An
Bord
Pleanála

Inspector's Report ABP-308943-20

Strategic Housing Development

333 no. residential units (121 no. houses, 212 no. apartments), creche and associated site works.

Figure 16.0 Proposed phasing plan for the subject residential development

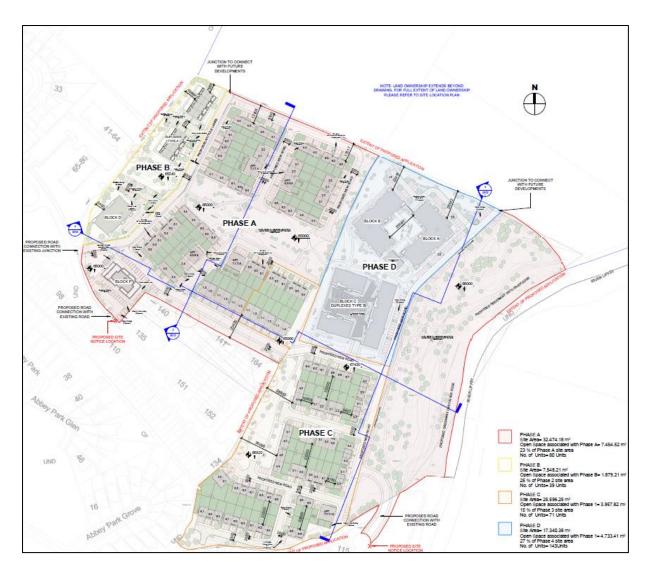
- The phasing for KDA1 requires the riverside footpath to be completed prior to unit 101.

- The applicant proposes the riverside walk after 109 units which is unacceptable.

Figure 19.0 Ground floor plan for Apartment Blocks A & B.

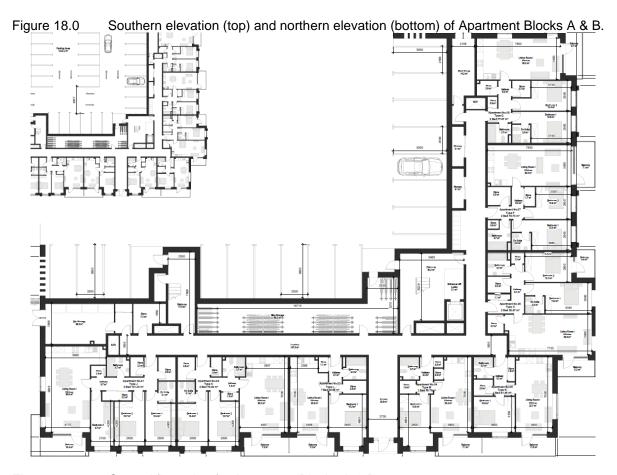
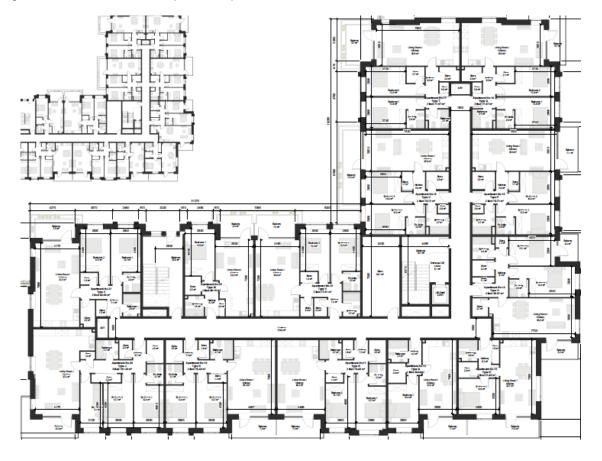
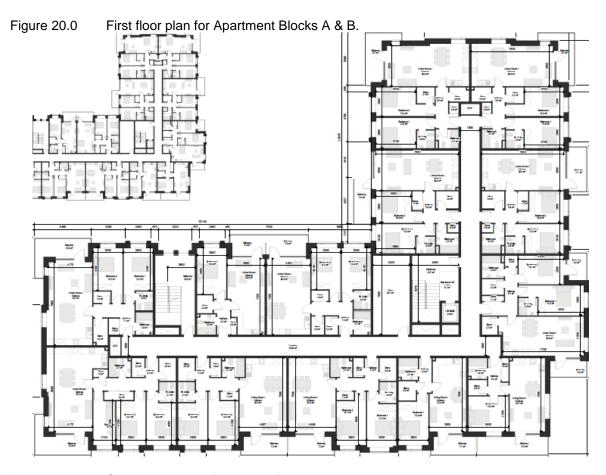
- The use of two estates for access would have a negative impact on pedestrian safety.
- The density and large apartment blocks are inappropriate at this location and will lead to car dependency.
- Apartment Block A, B & C will overlook other houses in the development.

- The apartments blocks should be reduced to 2 storeys in order to prevent overshadowing.
- The building heights do not comply with the requirements of the KDA and should be reduced to 2 storeys.
